**Consultation Response from KC,
Trees****2026/91969 land off, Fenay Lane, Almondbury, Huddersfield, HD5 8UJ****Erection of 6 dwellings, with associated access, landscaping, infrastructure and works****Date Responded: 22/07/2026****Responding Officer: JD****Responding Ref: 38/89**

Drawing Title:
Tree Impact Plan

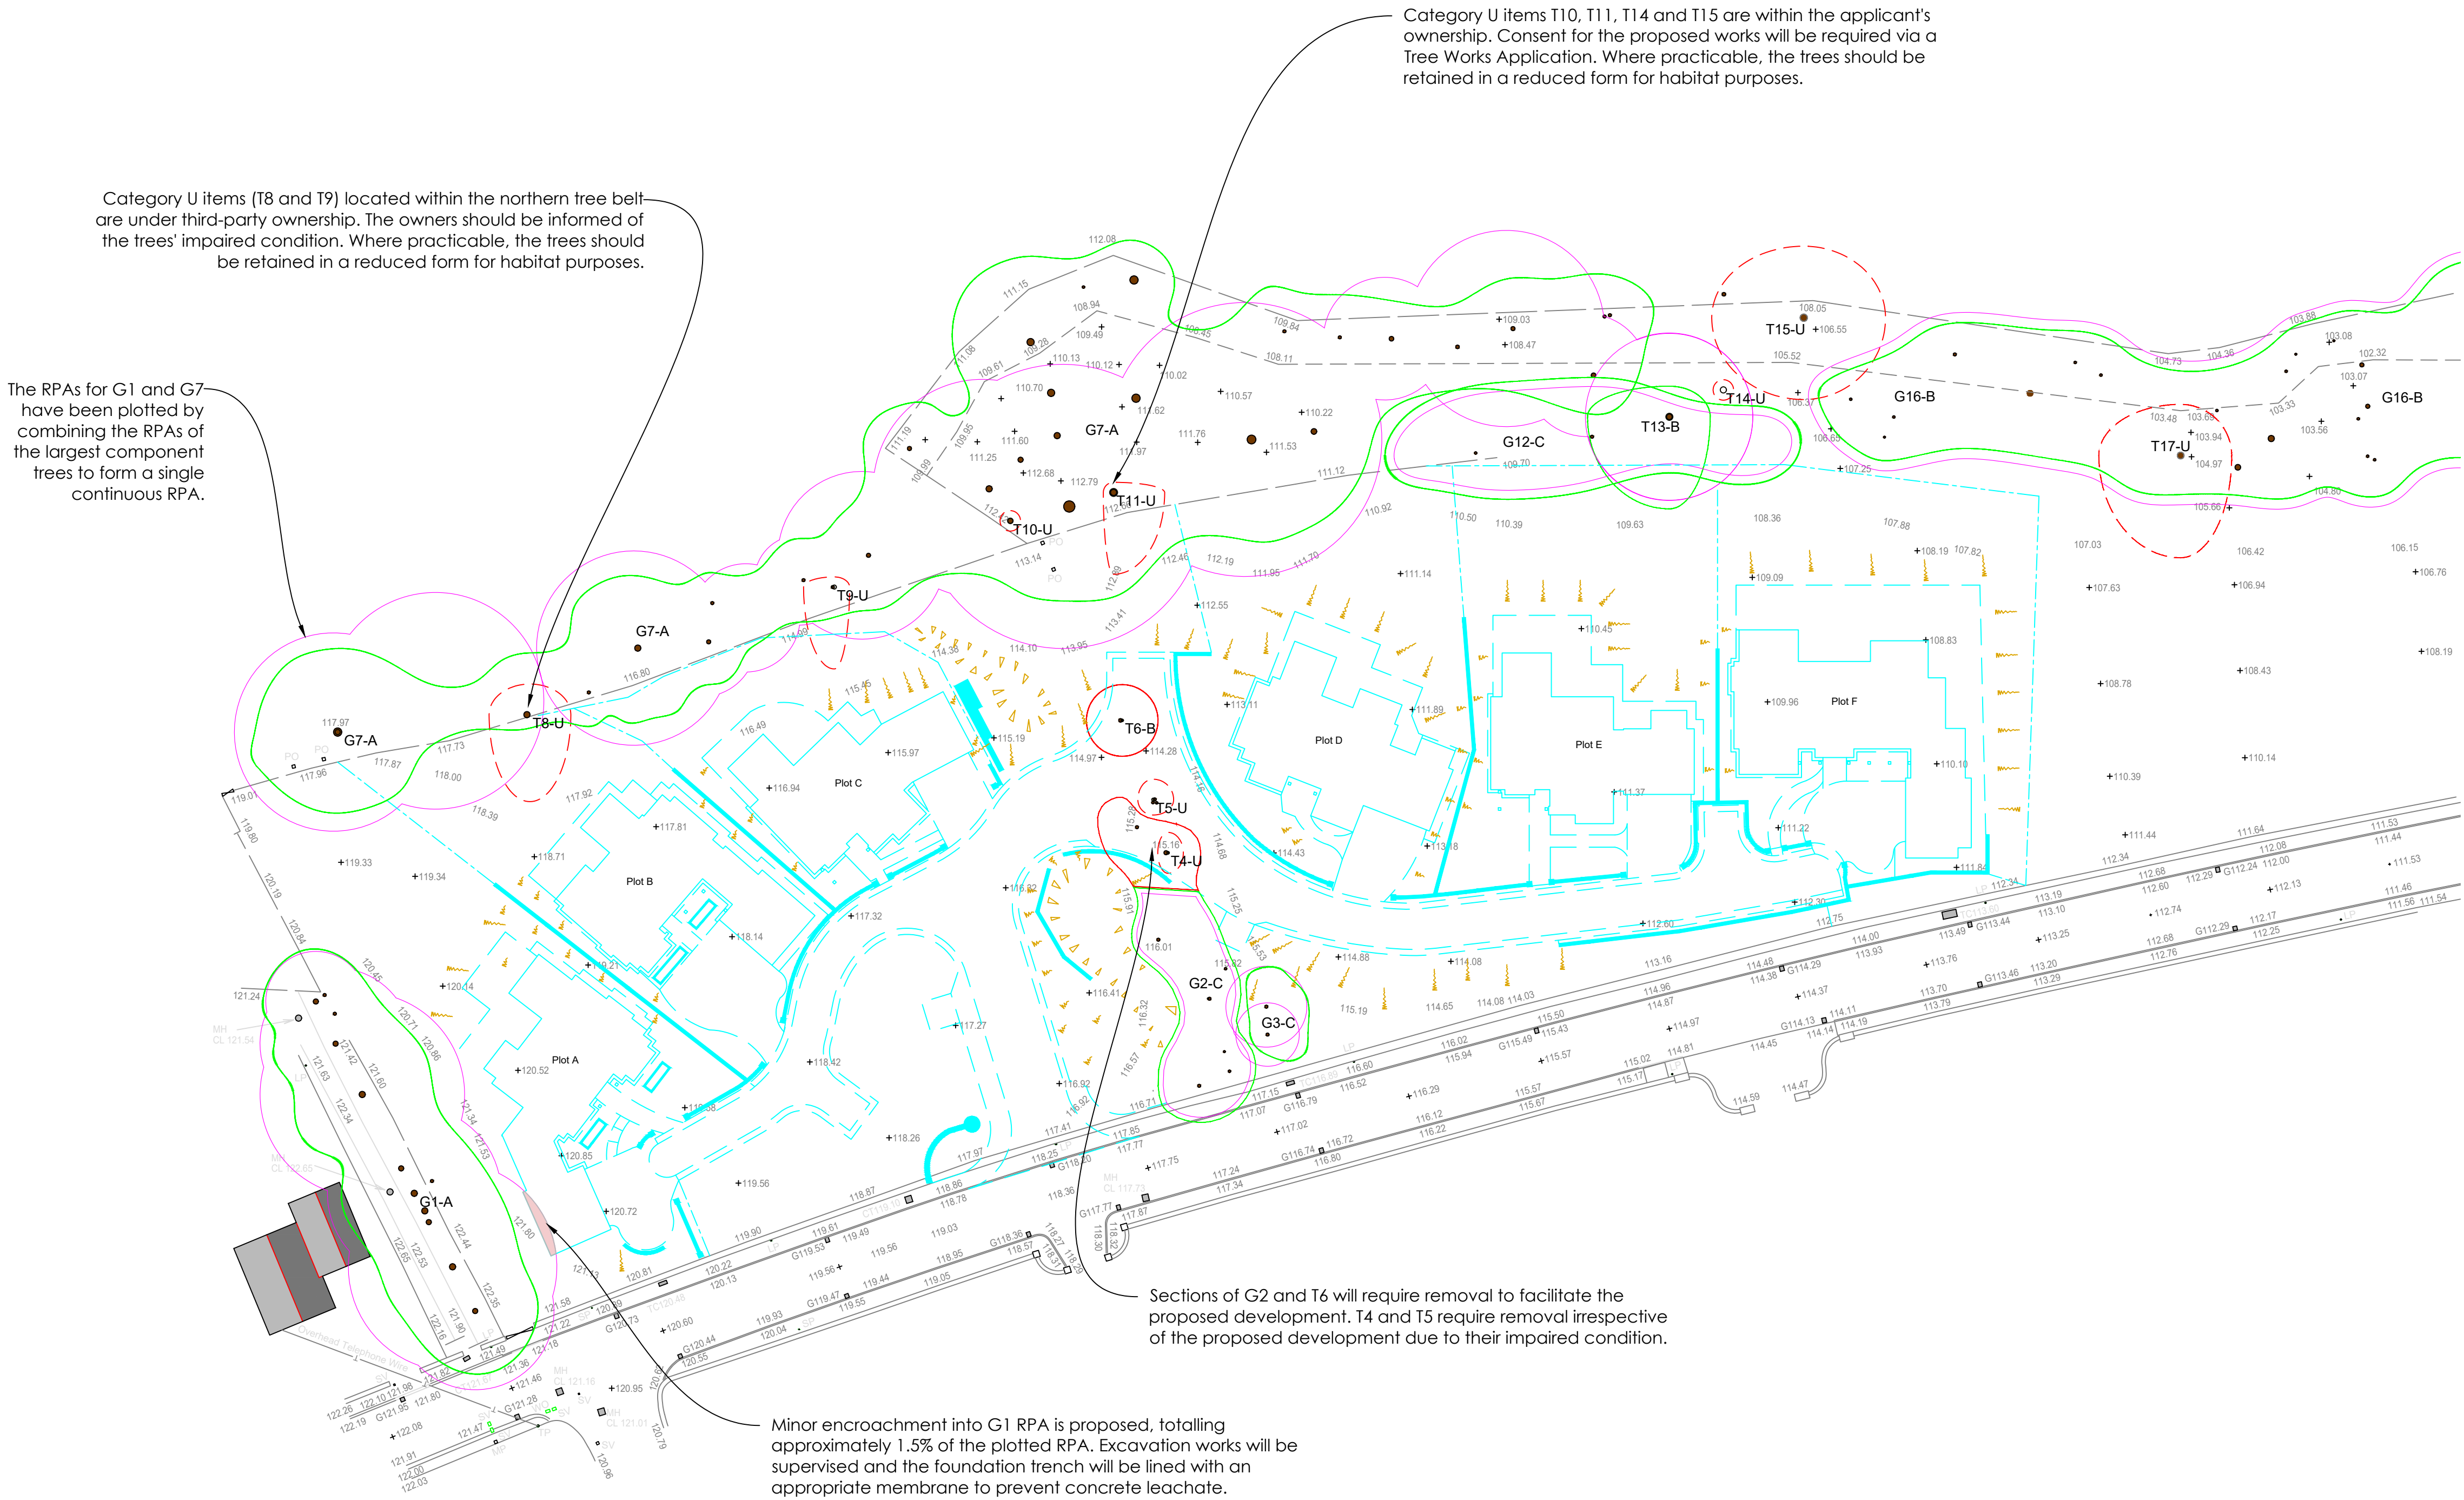
All designs are located outside of Root Protection Areas apart from a minor infringement into G1 RPA which is within the tolerable limits.

T4 and T5 require removal for arboricultural reasons and T6 and part of G2 are being removed to facilitate the road. This would all be deemed an acceptable loss due to the level of mitigation in proposed new planting.

There will need to be an Arboricultural Method Statement and Tree Protection Plan produced to ensure the adjacent trees are protected during construction but this can be done via condition.
